YorkshireWater

**Your Ref: 2025/1092
Our Ref: B/01496**

**Non-motorised user (NMU) bridge over A633 Grange Lane (A633), Stairfoot, Barnsley -
(BARNs) Demolition of existing non-motorised user (NMU) bridge, and construction of
replacement NMU bridge**

- 70111595-WSP-ELS-AZ-DR-LA-000021

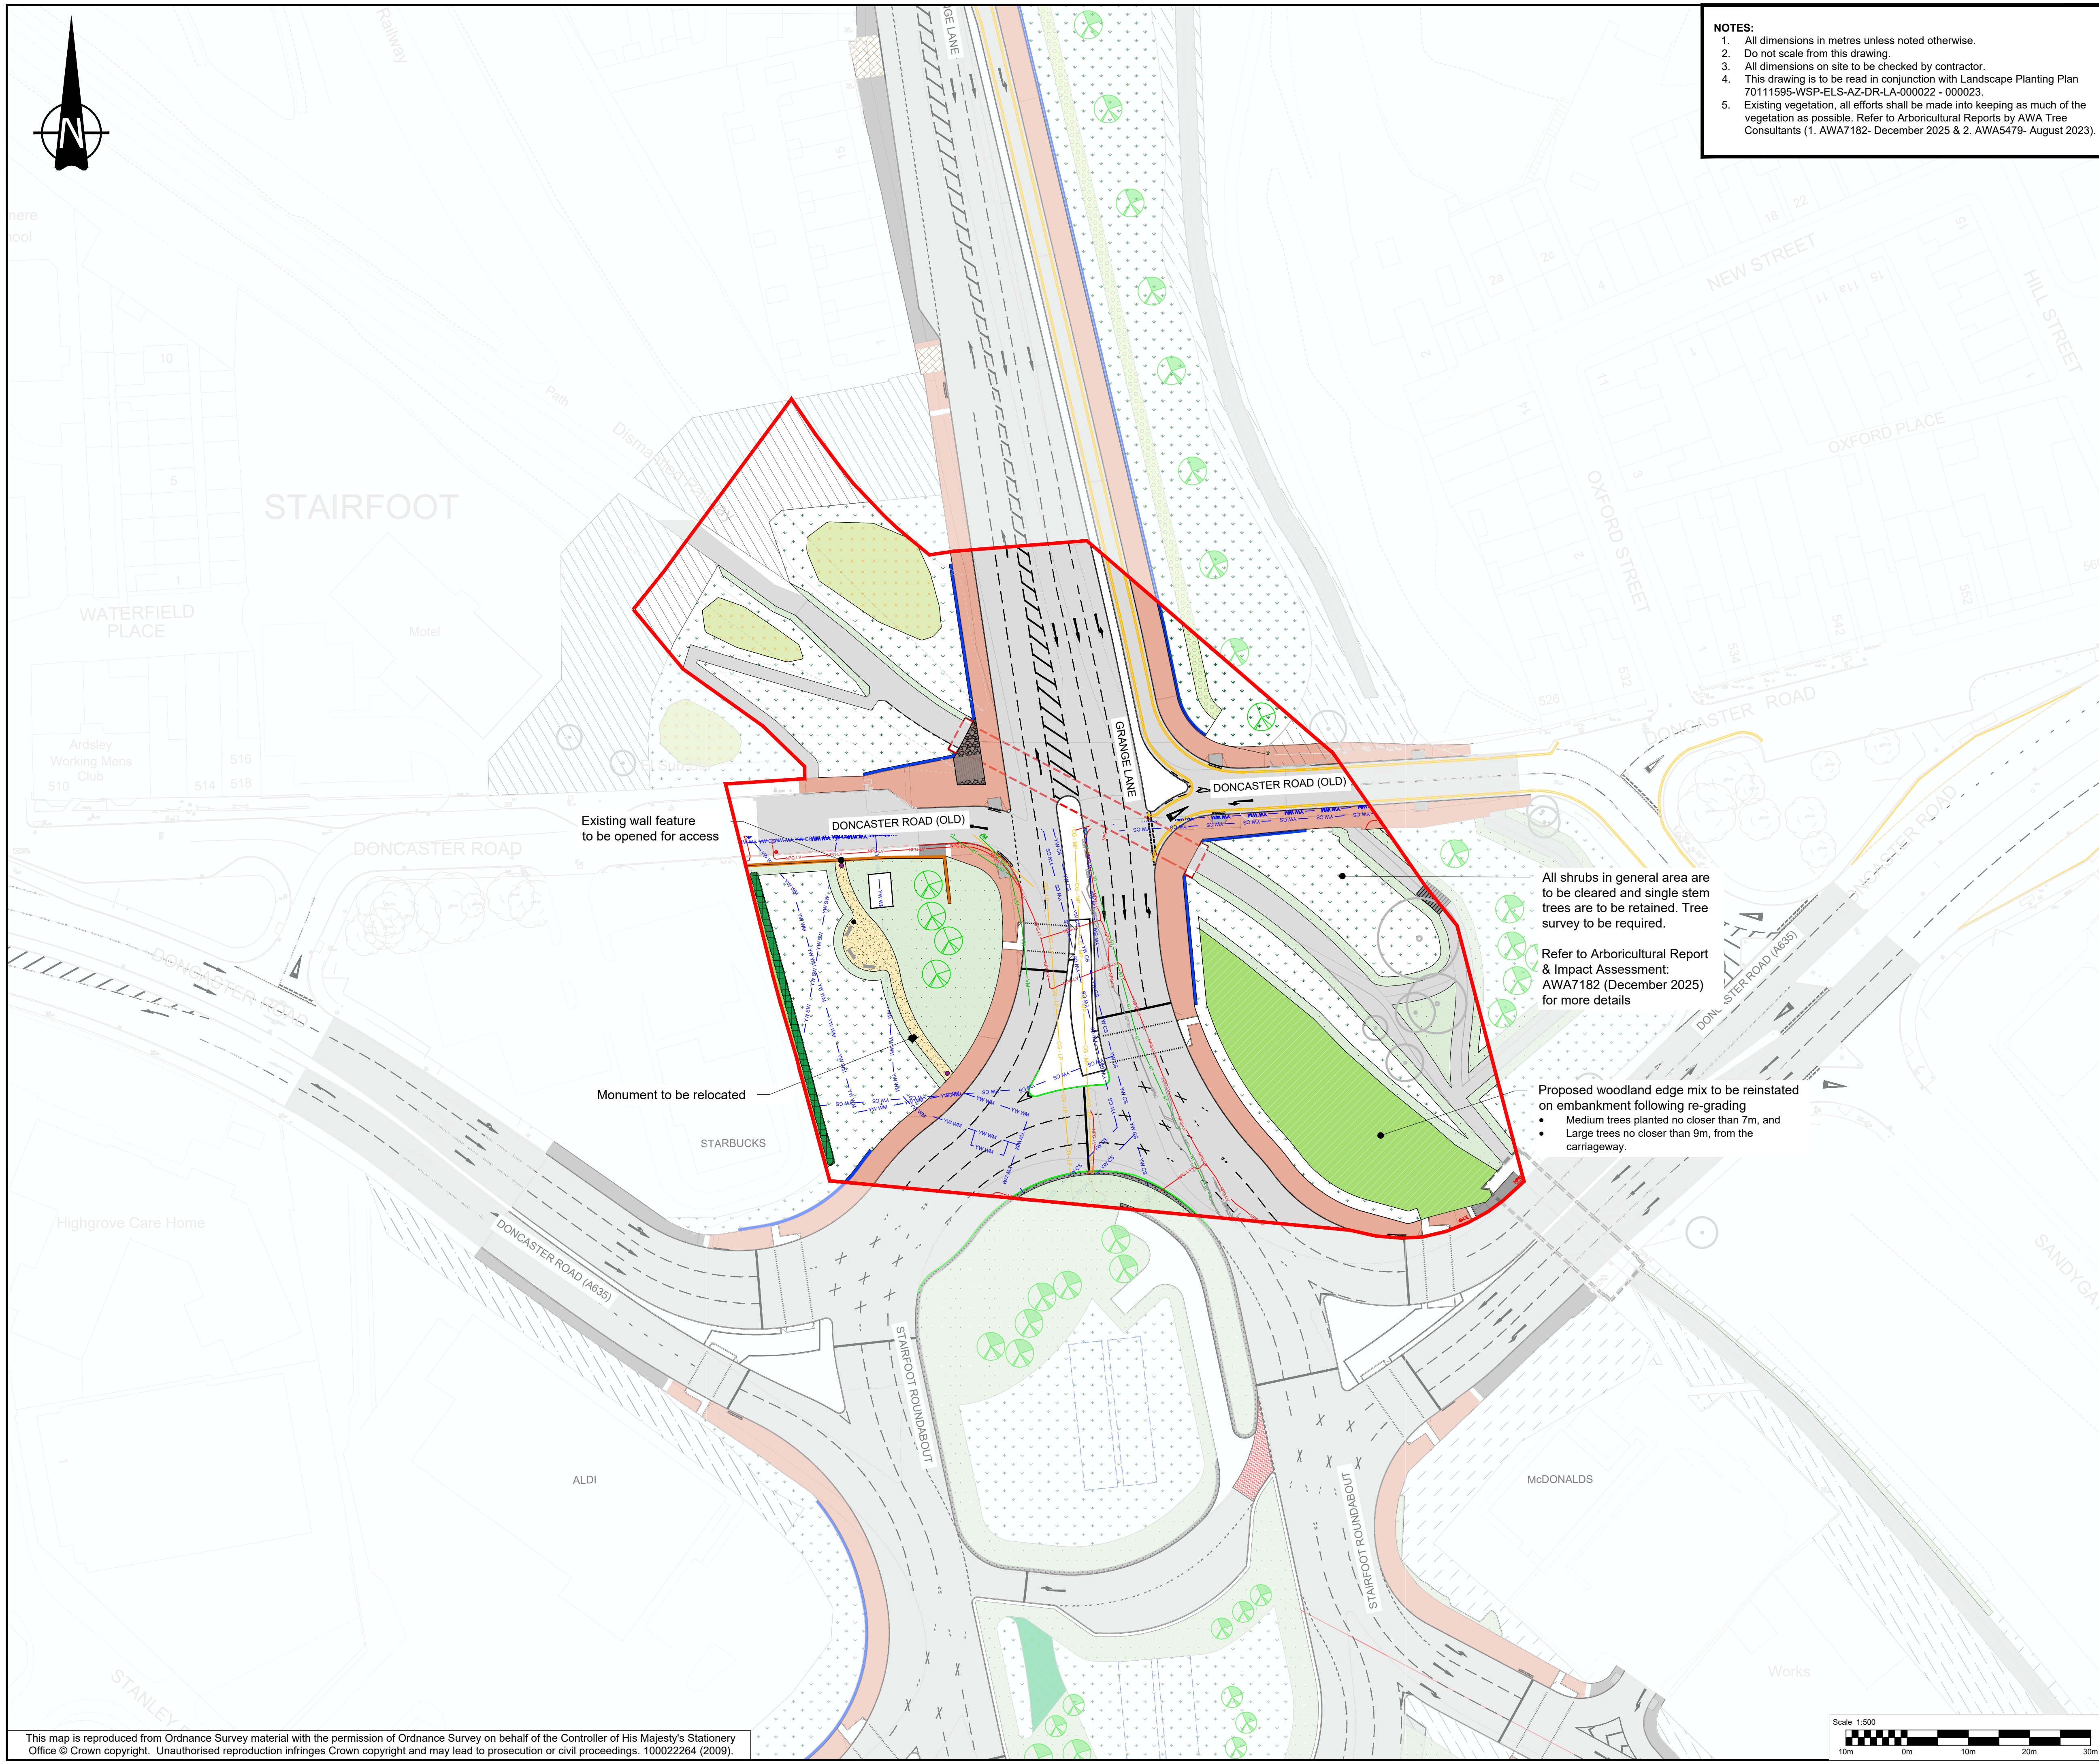
The submitted 'Landscape General Arrangement Planning Application' 70111595-WSP-ELS-AZ-DR-LA-000021 (rev P02) dated 20/08/26, as prepared by WSP shows adequate tree planting stand-off from both the public sewer network and the public waster network. Consequently, the objection can be removed.
